Please ask for: Mrs D Johnson
Email: daun.johnson@arun.gov.uk
Telephone: 01903 737762
Our Ref: BE/48/25/PL
Your Ref:
Date: 3rd April 2025

Application for Planning Permission

Development: 7 No. residential dwellings and associated works including new access. This application is a Departure from the Development Plan and is in CIL Zone 3 and is CIL Liable as new dwellings.
Location: Rear Of Regal House And Wayside Shripney Road Bognor Regis PO22 9NP

Detached Garage - (Plot 5)
Proposed Plans and Elevations

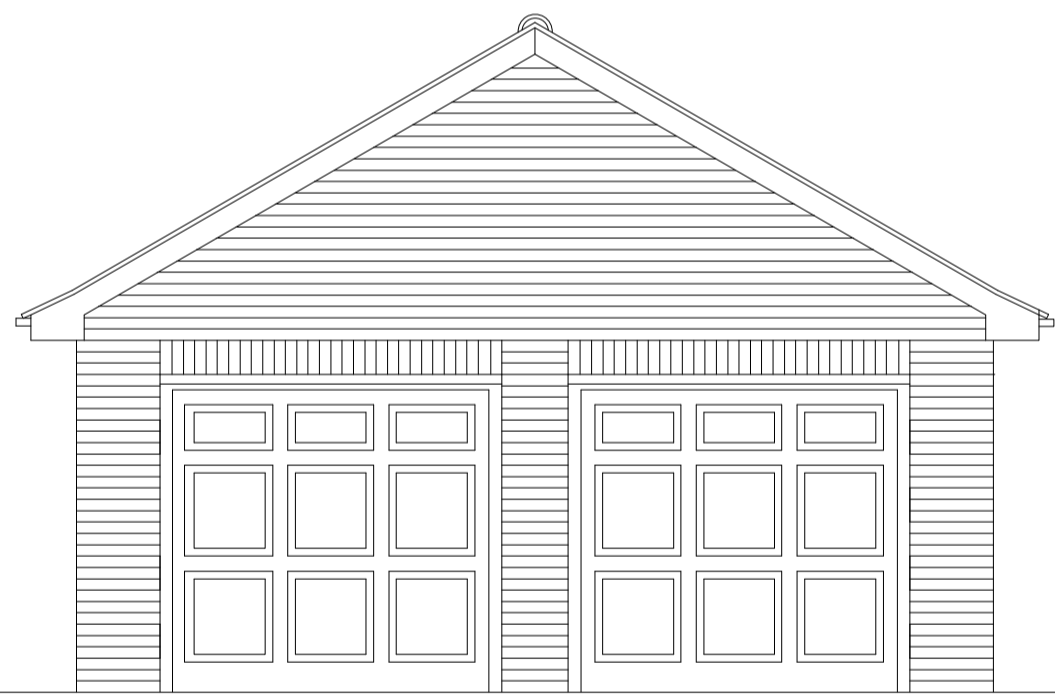
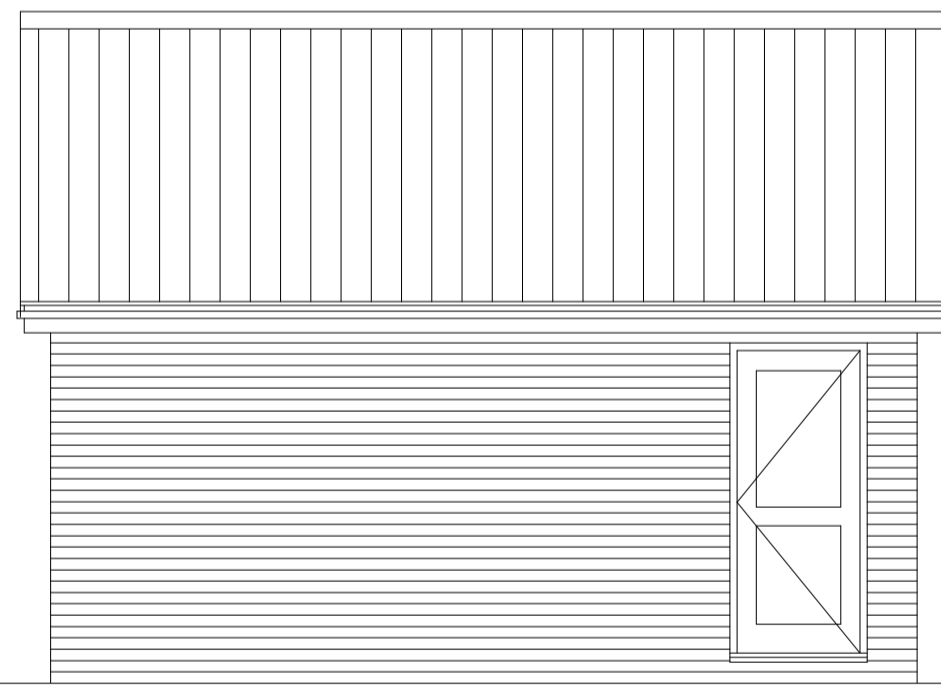
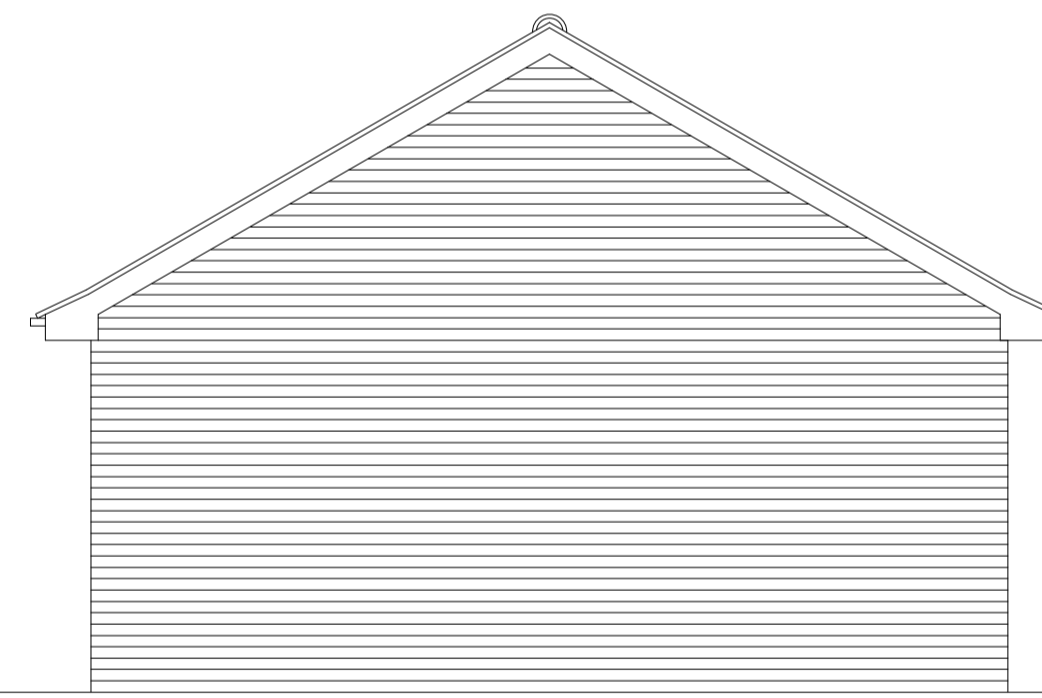
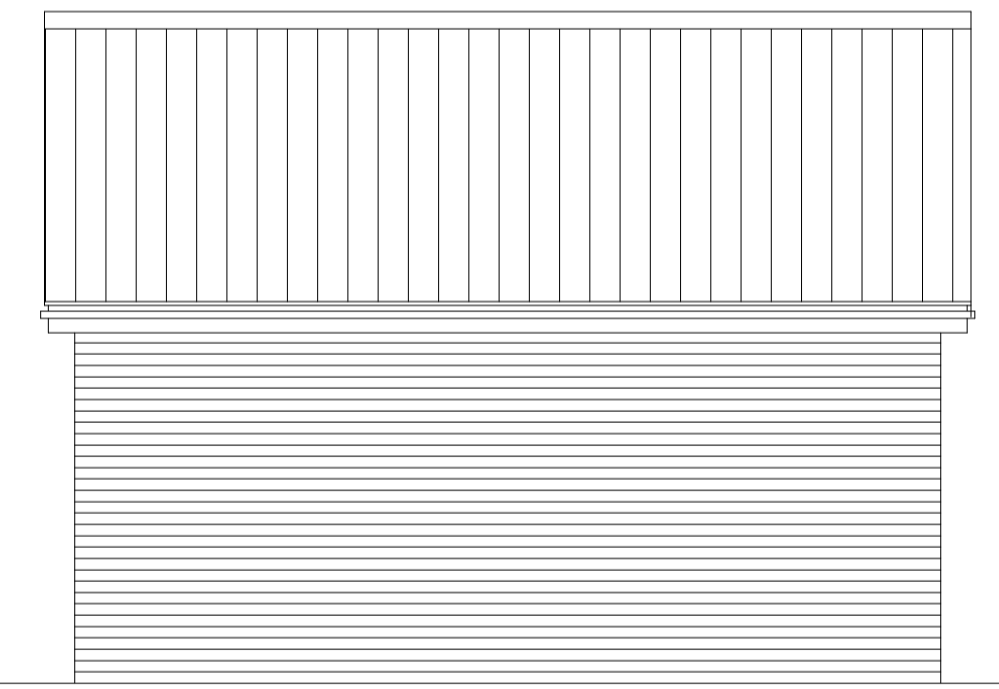
The elevations for Plot 5 are not labelled correctly. Please amend accordingly.
